**From:** Amanda Scholes on behalf of Planning.Responses  
**Sent:** 01 December 2021 09:50  
**To:** Planning Scanning  
**Subject:** FW: Planning Re-Consultation on: Y/156/21/DOC

**Application No:** Y/156/21/DOC  
**Registered:** 3rd November 2021  
**Site Address:** Land East of Drove Lane Yapton BN18 0EB

**Description of Works:** Approval of details reserved by condition imposed under Y/92/17/OUT relating to conditions 4-phasing for construction of dwellings & associated highways & public areas, 9-surface water drainage, 16-Construction Management Plan, 21-Travel Plan, 22-energy conversation, on site energy renewable devices & 25-electric vehicle charging strategy.

I am able to inform you that I have received an amendment to the above application dated 23rd November 2021 relating to: Amended Drainage Plans (at Applicant request)

Permeable Paving Connection Detail To Proposed Surface Water Network

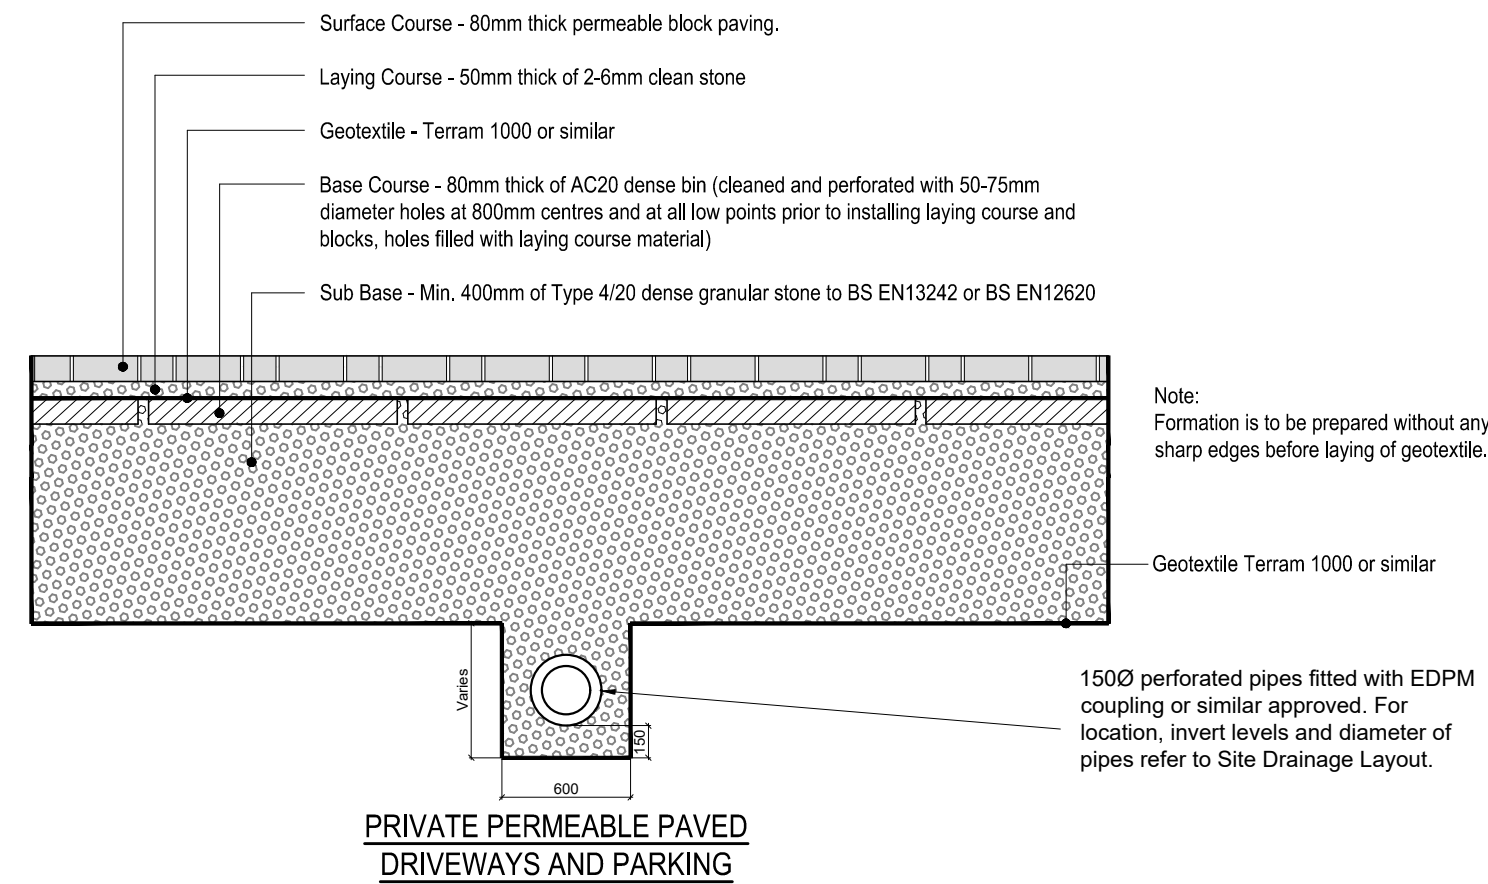
1. Suds detail sheet appears to detail and list features which are to be lined with an impermeable liner, contrary to the statement provided. Please confirm whether all features below peak groundwater level are to be impermeably lined.

6. Hydrobrake construction detail drawing needs to show cable for operating bypass door and where this will be fixed.
7. Specific geotextiles should be included on construction details of attenuation tanks, rather than just stating "permeable geotextile" a specific type should be specified.

11. All permeable paving areas should be reviewed to ensure any which have formation levels below peak groundwater level are lined.
12. Calculations include 450mm depth of sub-base, yet construction detail states minimum 400mm. Please update construction detail drawing.

13. Any permeable paving sub-bases which have rwp's discharging into them should be impermeably lined, or should ensure that point of discharge of rwp is a minimum of 5m from buildings.

4. There are inconsistencies between permeable paving sub-base formation level shown on plan and those in calculations.
5. Swale 3 has inconsistent dimensions between plan and calculations.
